**Application by Keuper Gas Storage Limited (KGSL) for a Development Consent Order for
Underground Gas Storage Facility at Holford Brinefield**

**Comments of Cheshire West and Chester Council on the Examination Deadline 3
Submissions made by KGSP**

7th June 2016

Comments on KGSP response to LIR and CWAC Written Representation (KGSP document ref 10.8)

WHITLEY PUMPING STATION - KGSP - ELEVATIONS

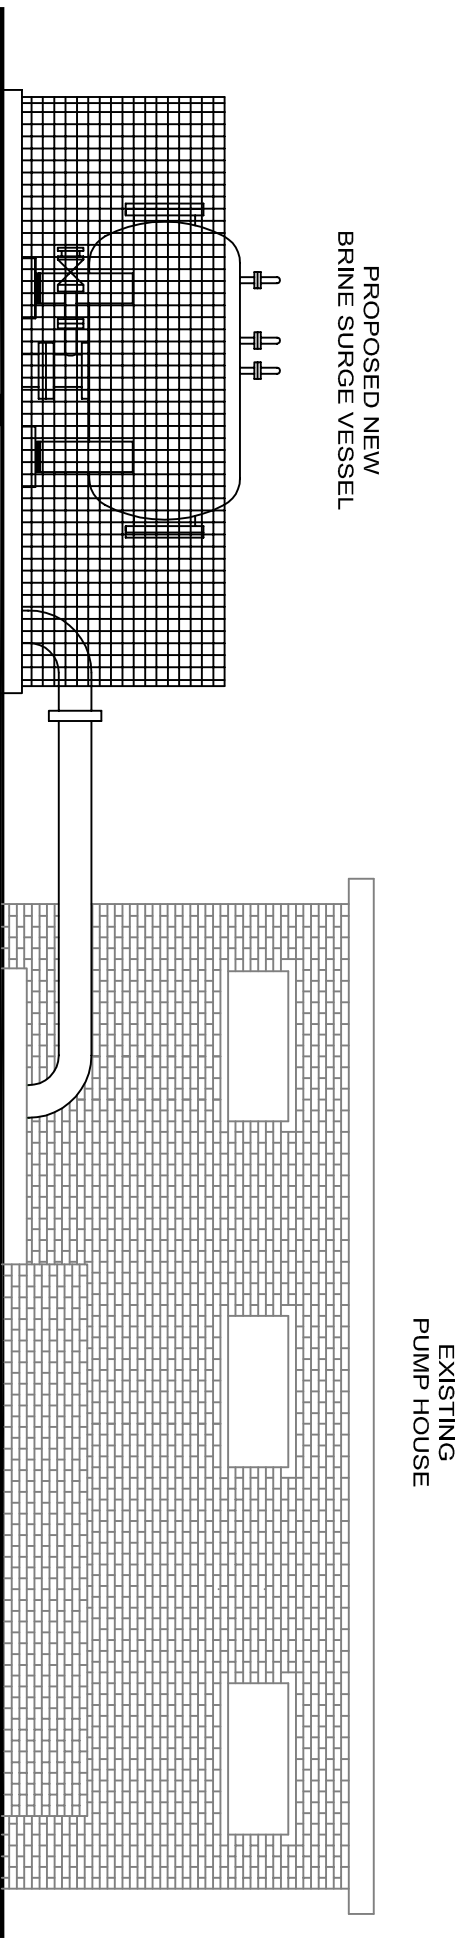
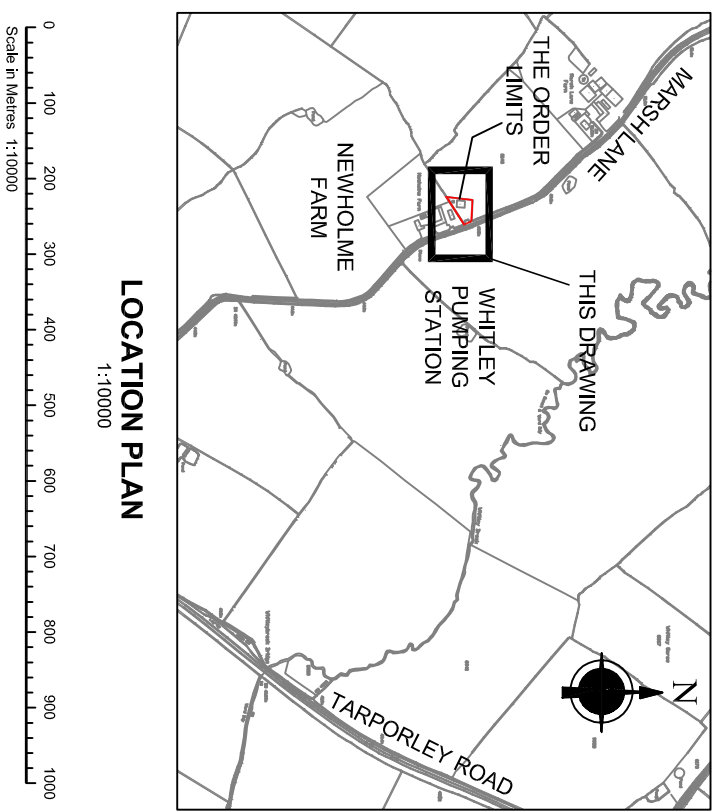
3. **Paragraph 3.2.8-11** – The comments made with regards to ecology are noted. The Council notes that its comments made through its written representations with regards to barn owl surveys at the MAA (paragraph 28) and the Whitley Pumping Station (33) have not been addressed.
